## POST EPC MEMORANDUM

TO: CABQ Development Facilitation Team (DFT)  
FROM: William Steele, Senior Planner  
DATE: 05/05/25  
RE: PR-2025-011387, SI-2025-00040 – Site Plan – EPC

The Agent, Consensus Planning, Inc, for Pulte Group, has worked with Staff to fulfill post EPC requirements to meet Conditions of Approval 1-11, for a Site Plan – EPC, for an approximately 60 acre portion of Tract N-1, Correction Plat of Tracts N-1 & N-2, Watershed Subdivision (AREPL of Tract N Watershed Subdivision), located at 9601 Tierra Pintada Blvd. NW, at the NW corner of Arroyo Vista Blvd. NW and Tierra Pintada Blvd. NW, containing approximately 110 acres. See EPC Notice of Decision (NOD) dated March 20, 2025.

PLANTING PLAN

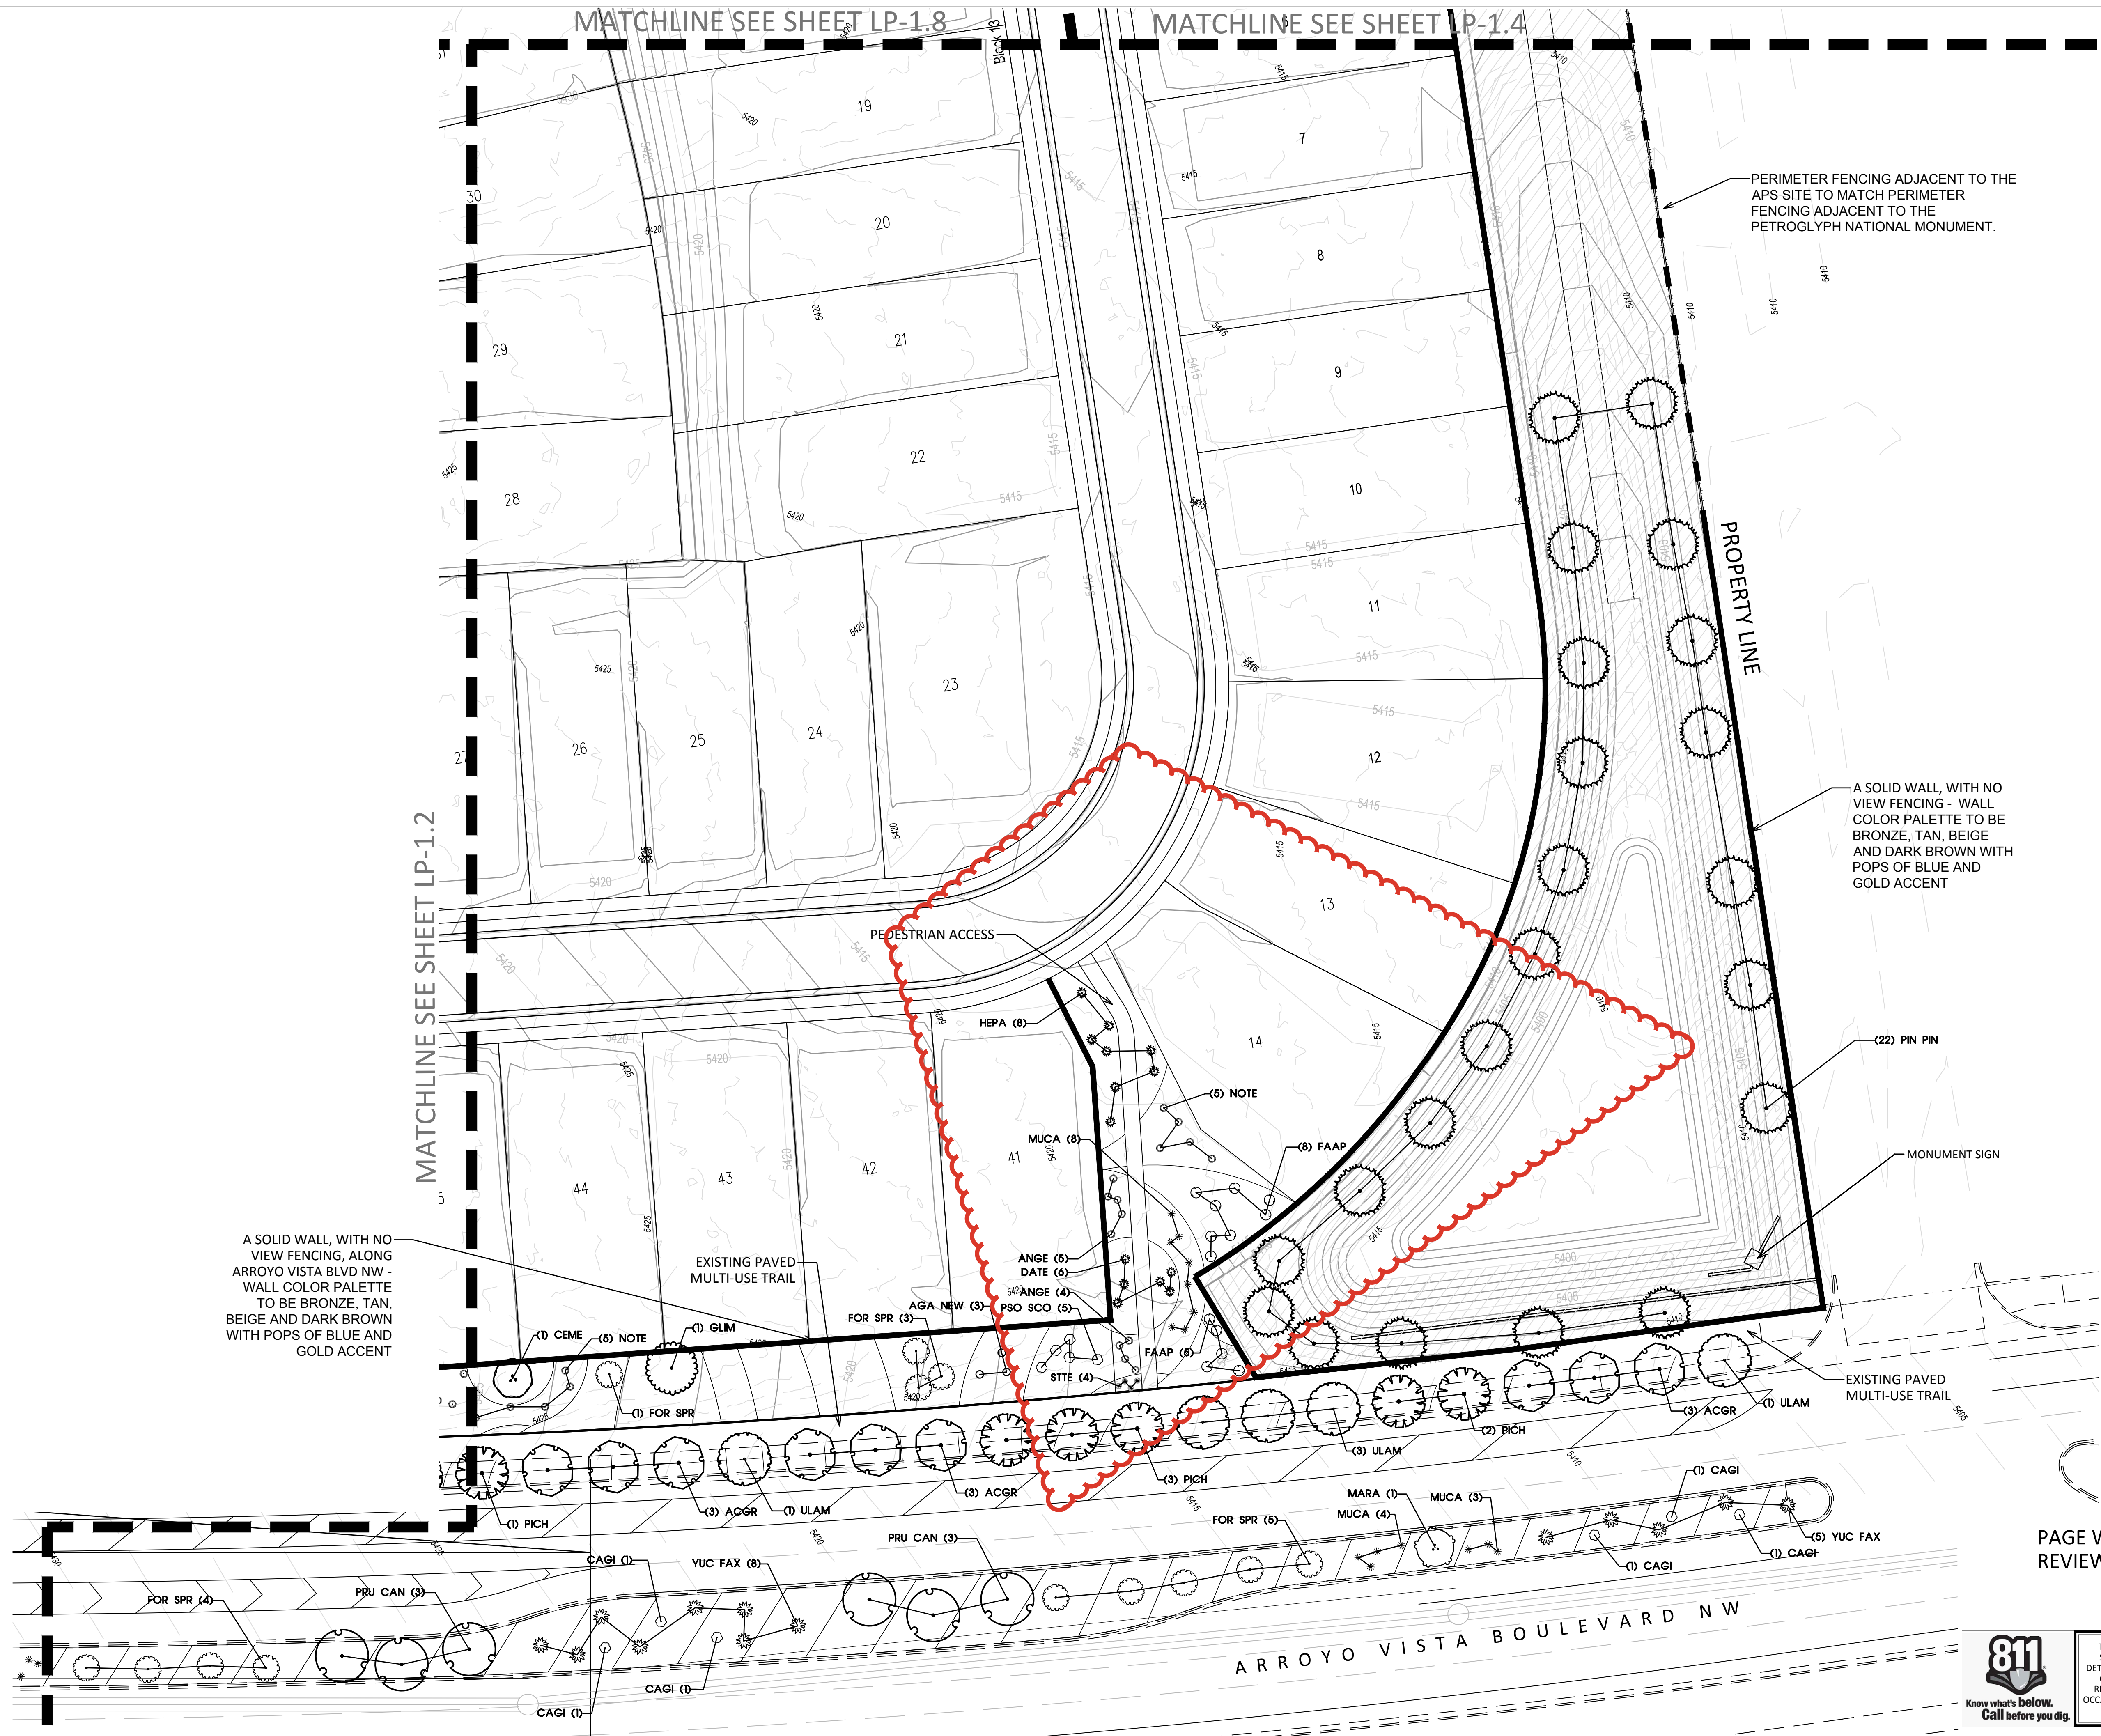
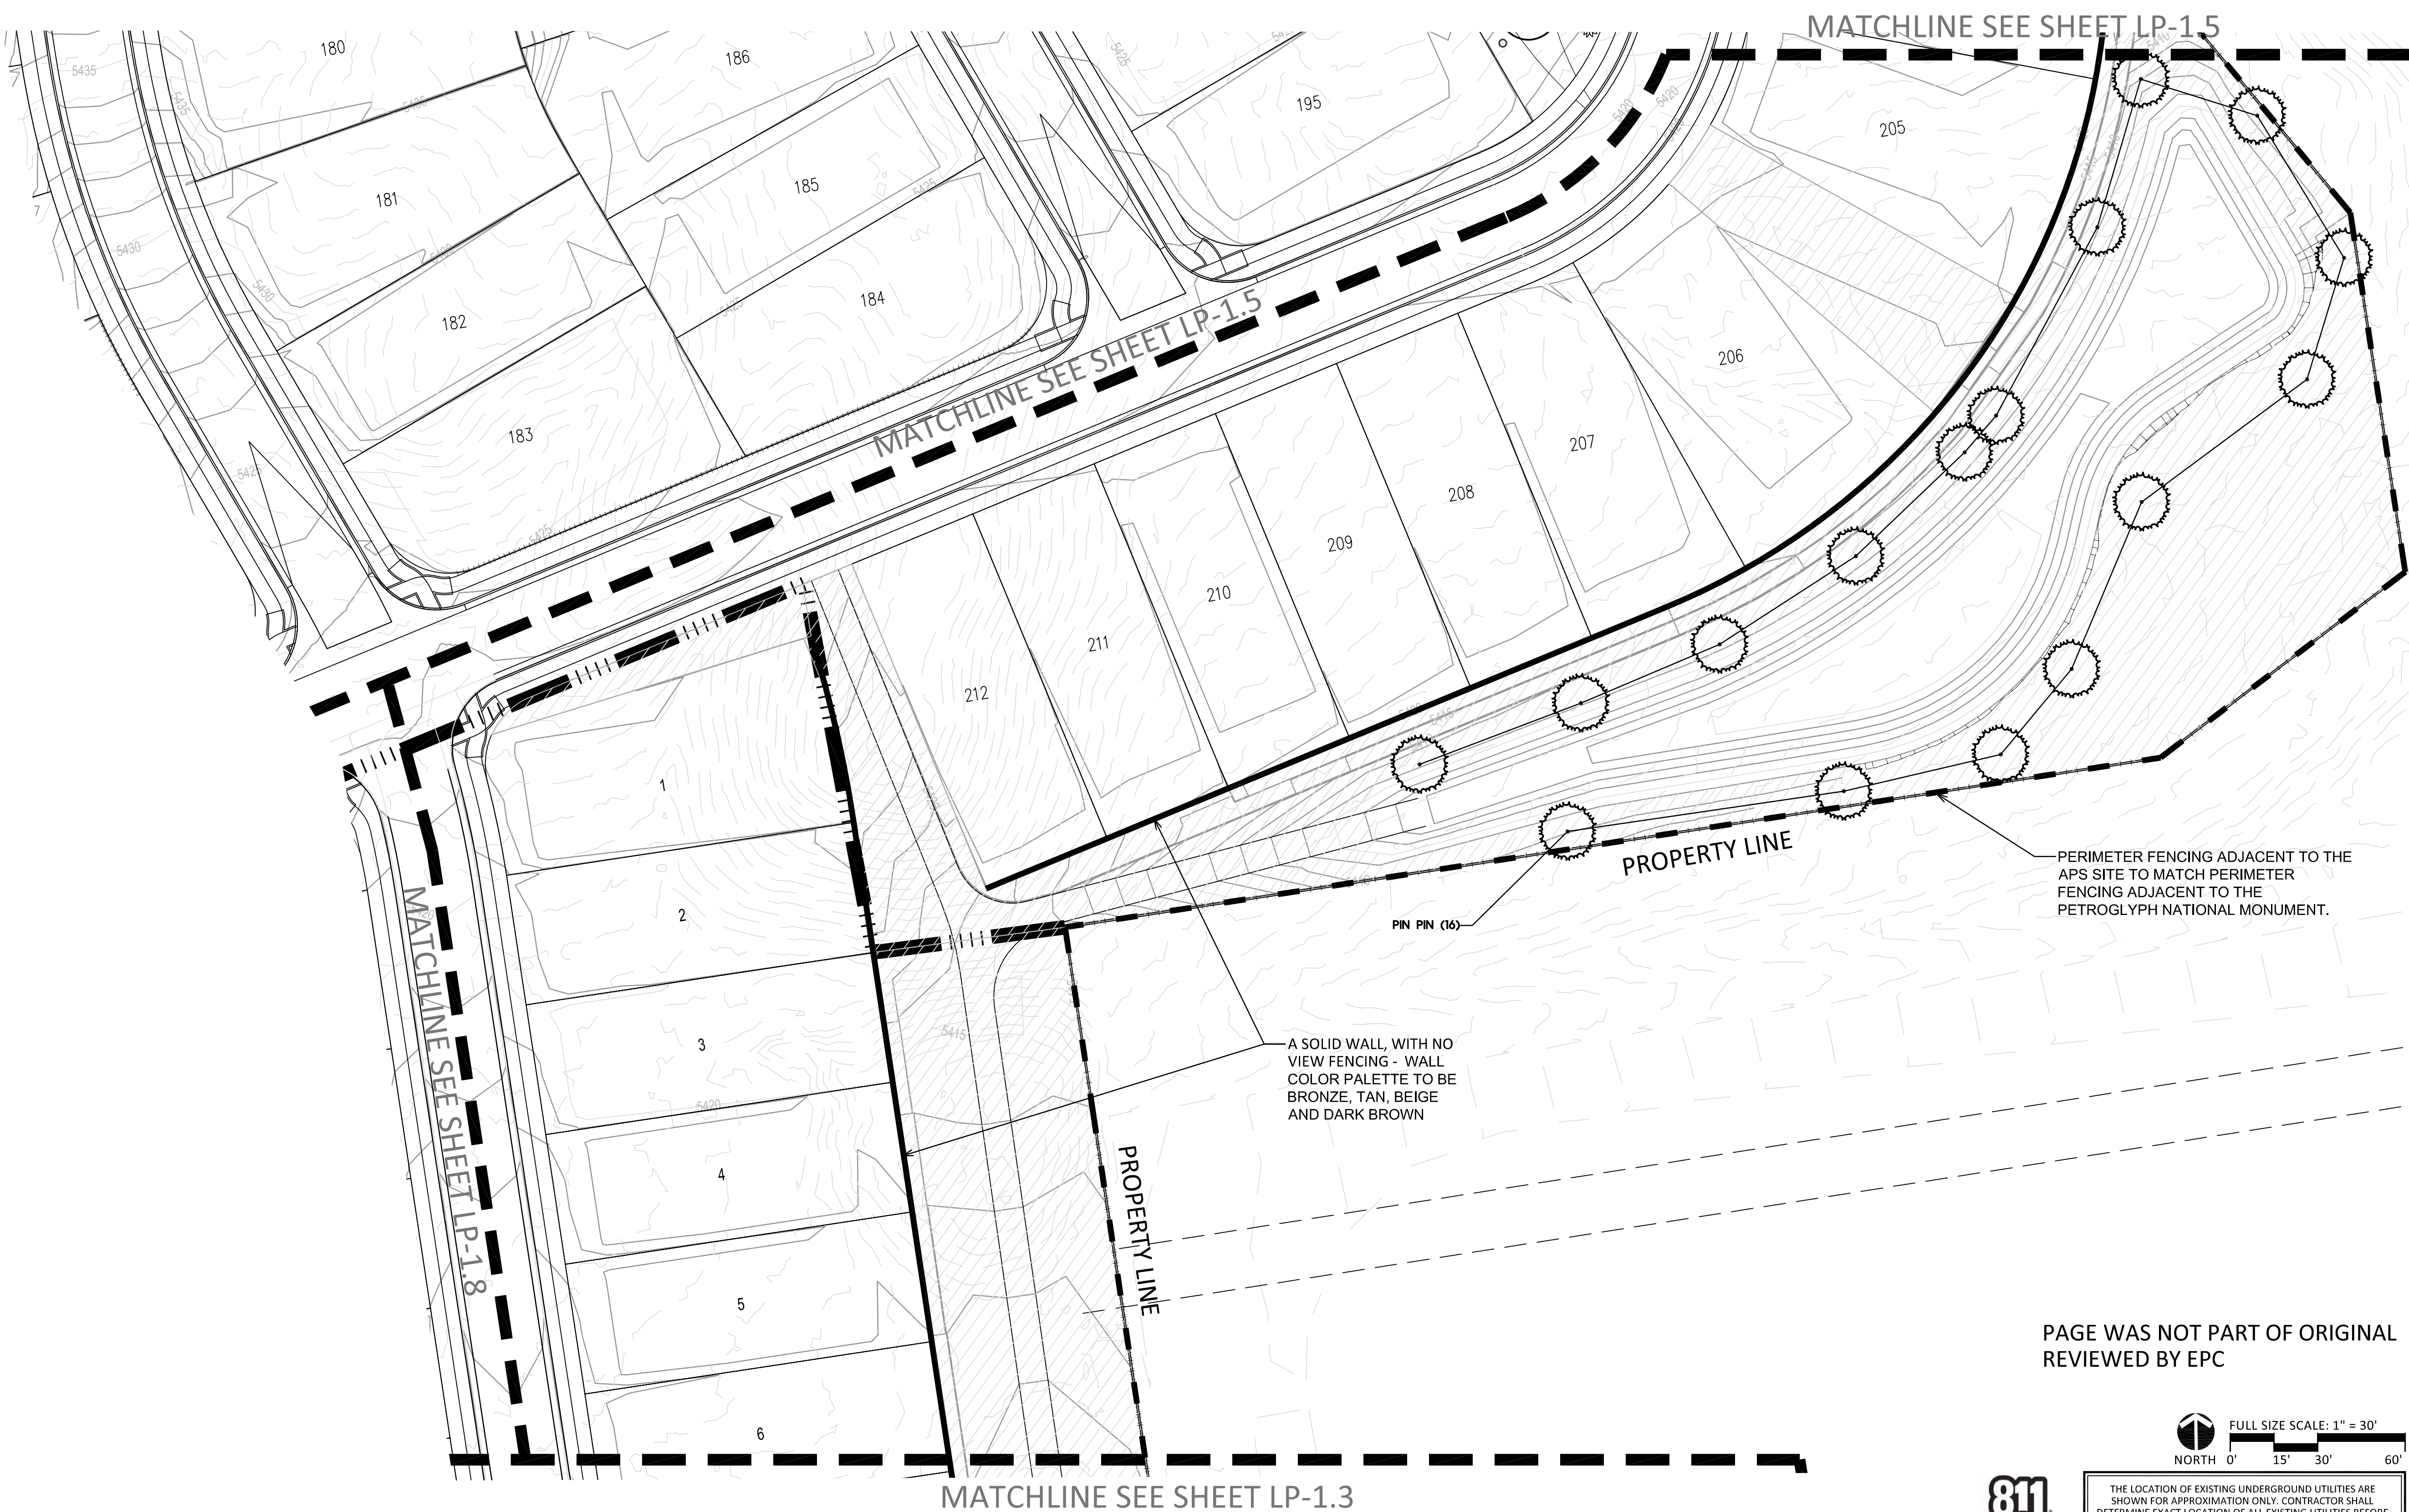
1. The following sheets included in the Post EPC review set were not approved by EPC and will not be reviewed by the Staff Planner as part of EPC's Conditions of Approval in the March, 20, 2024 NOD. These sheets shall be removed from the EPC final sign off set:

- a. PLANTING PLAN sheet
  - b. PROTOTYPICAL DETAILS sheet
  - c. PLANTING PLAN
  - d. PHOTOTYPICAL DETAIL
2. The following sheets were approved by the EPC are missing from the Post EPC drawing set. These shall be submitted to staff for review.
